August 5, 2003

RE: Waiver Request 126 Hussey Rd. (089 E023)

This office has reviewed your request dated 6/25/03, with regard to the width of the spiral stairway, which goes from the second floor to the third floor.

(3<sup>RD</sup> FLOOR (EXIST ONLY)  
STAIR LADDER ACCESS (AS IS).  
\* USE AS DEN - UNCHANGED)

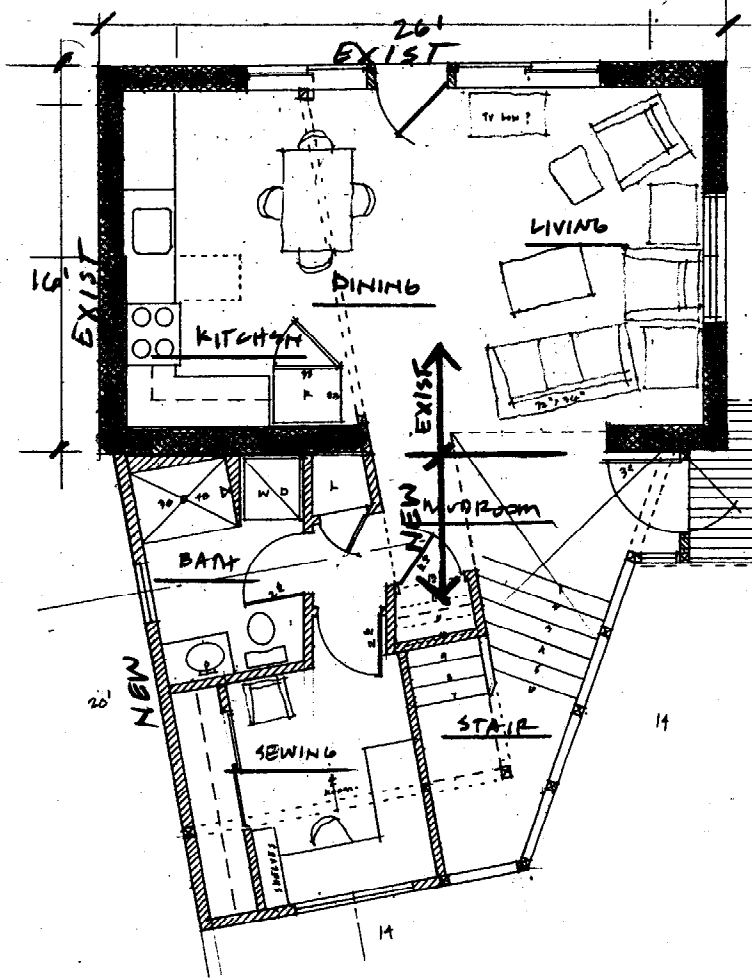
- 1) The existing interior access is with a ladder, type stairway, which has a 6" net, tread and an 11" net riser, open without guards.
- 2) The 1/19/03 engineering report from Becker structural indicates that increasing the opening for a wider, code compliant spiral would adversely affect the structural integrity of the slab.
- 3) The use of the structure is a single-family dwelling.
- 4) Section 1014.6.4 of the 1999 BOCA requires that the minimum tread width for a spiral stair is 26 inches.

The applicant proposes that the applicant be permitted to install a spiral staircase that has a tread width of 20 inches

Based on the above facts the City of Portland hereby grants the request based on the following conditions:

- 1) That the Spiral Staircase complies with all other applicable sections of the 1999 BOCA Code. (Including but not limited to net treads & rise, headroom, guards/handrails and semi solid risers)
- 2) That an emergency escape (egress window) pursuant to Section 1010.4 is installed
